**HAYES STRUCTURAL**  
Consulting & Design, PLLC

**Date:** August 7, 2024

**Re:** 24-FRM-101  
Framing Inspection  
Lot 22 Tobacco Road  
89 Looping Court  
Angier, NC 27501  
Permit No.: SFD2405-0100

2.02F
Second Floor Framing Plan
Elevation "D"

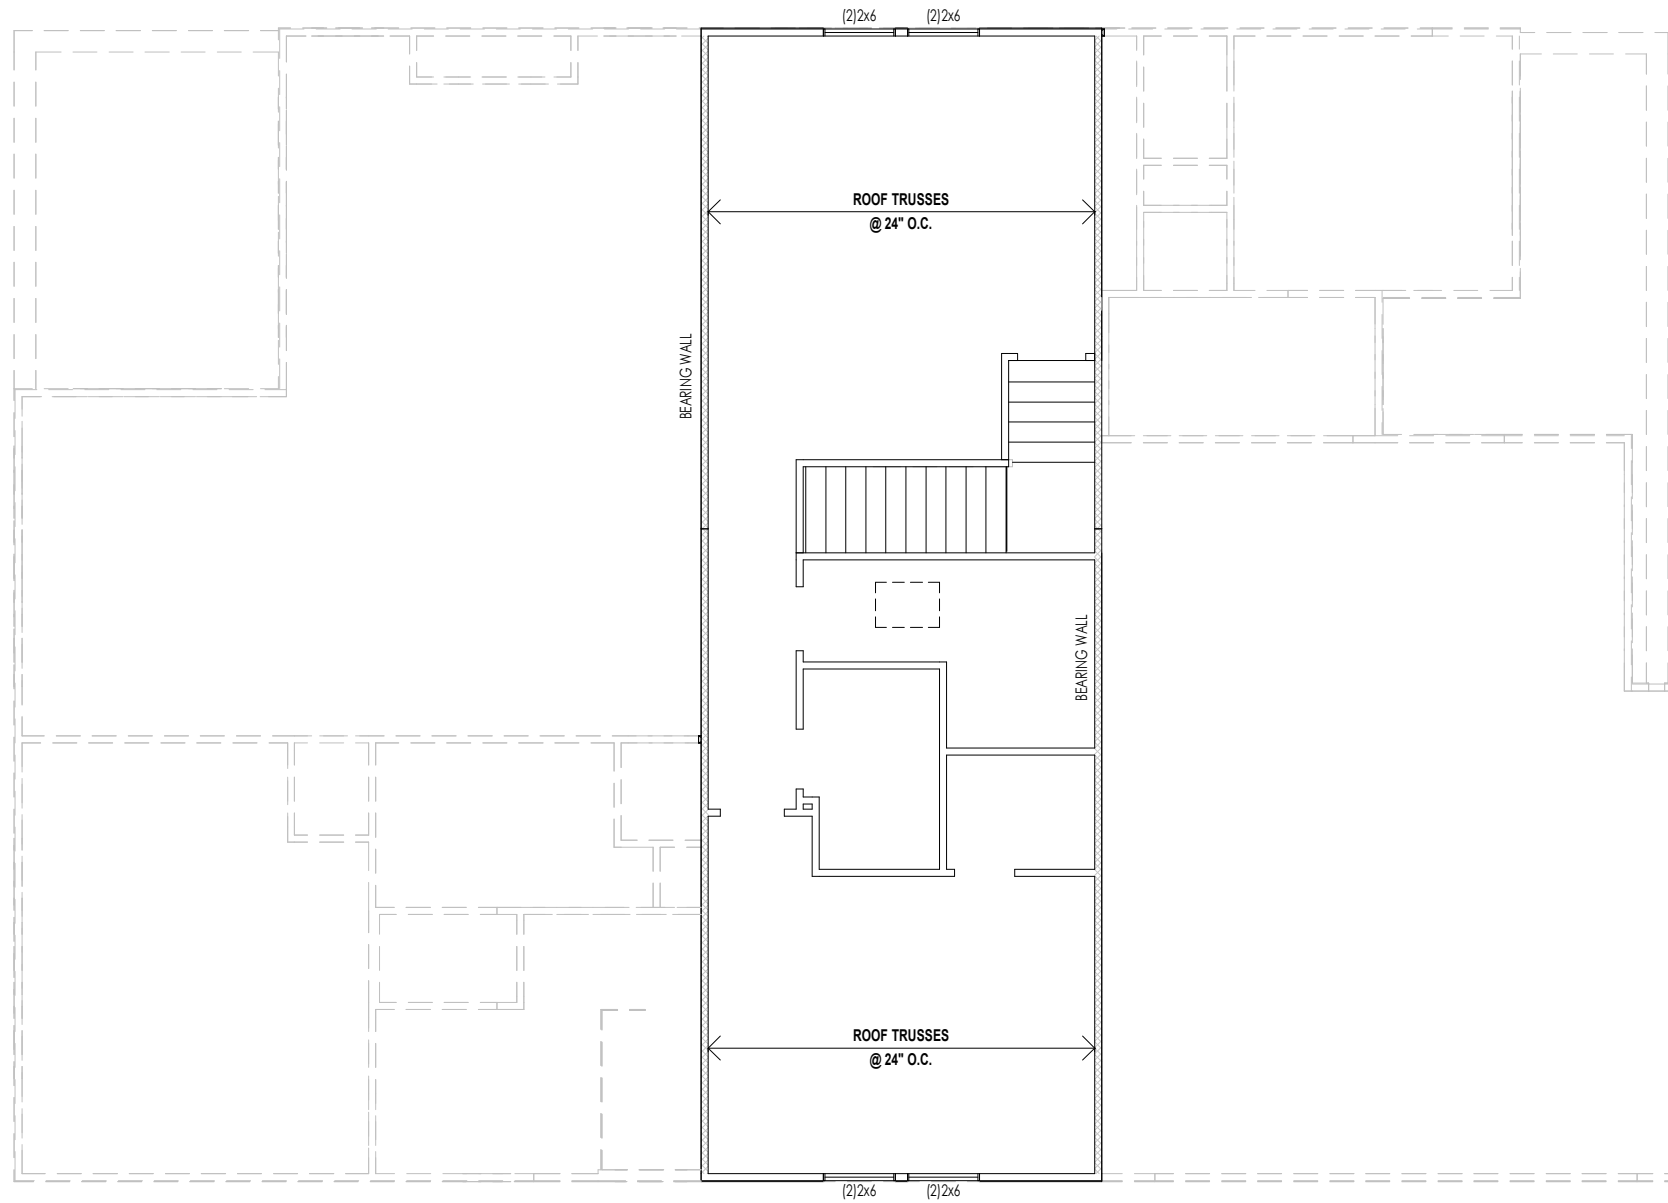
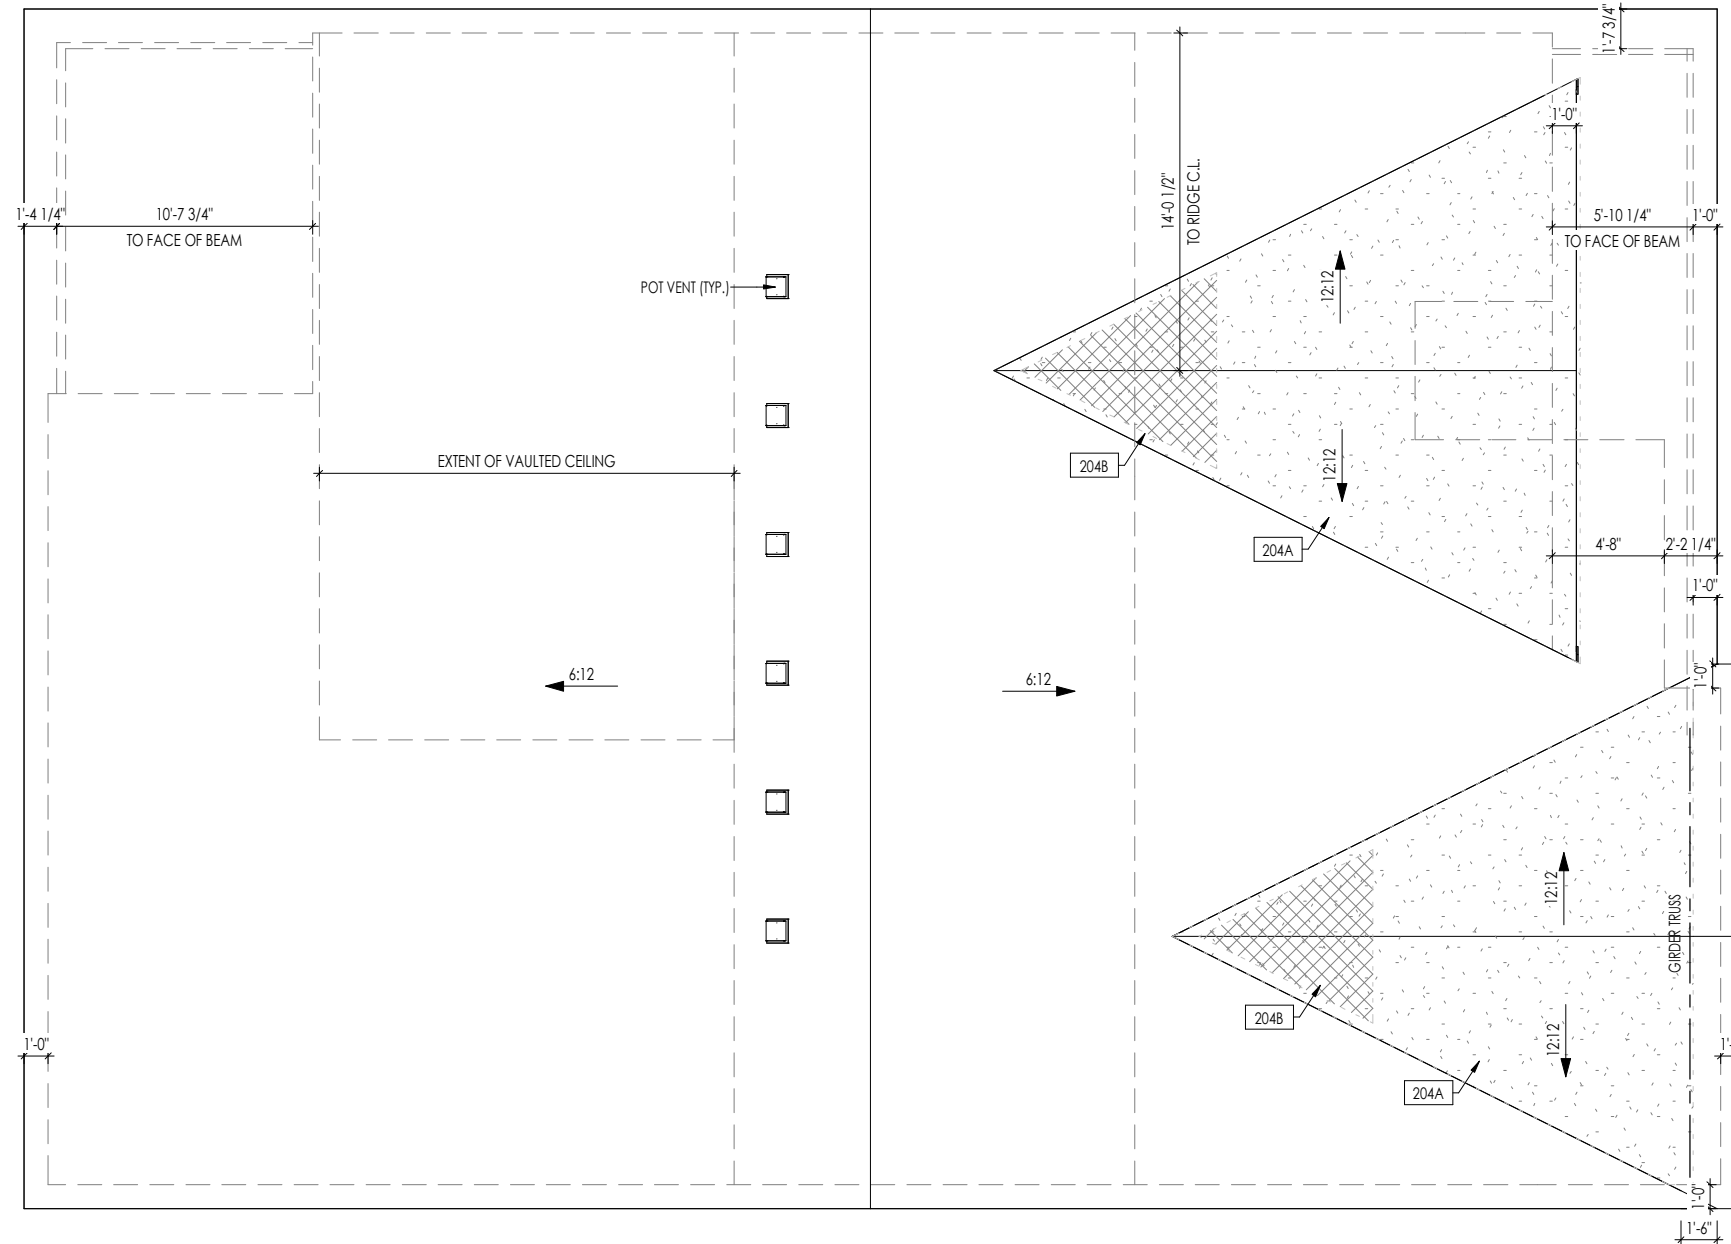
A (2) 1 $\frac{3}{4}$ "x9 $\frac{1}{4}$ " LVL header was installed above the 4/0 transom window opening per plan. The header was installed directly beneath the double top plates and is supported by (2) jack studs and (2) king studs at each end. The perpendicular (2) 1 $\frac{3}{4}$ "x14" LVL flush beam bears on the double top plates above the header.

Analysis revealed the "as-built" (2) 1 $\frac{3}{4}$ "x9 $\frac{1}{4}$ " LVL header is suitable to support the imposed loads. The plan specified (4) stud column is not required at the right end of the flush beam as the header is suitable to support the flush beam without intermediate bearing and is installed directly beneath the double top plates. No modifications are required.
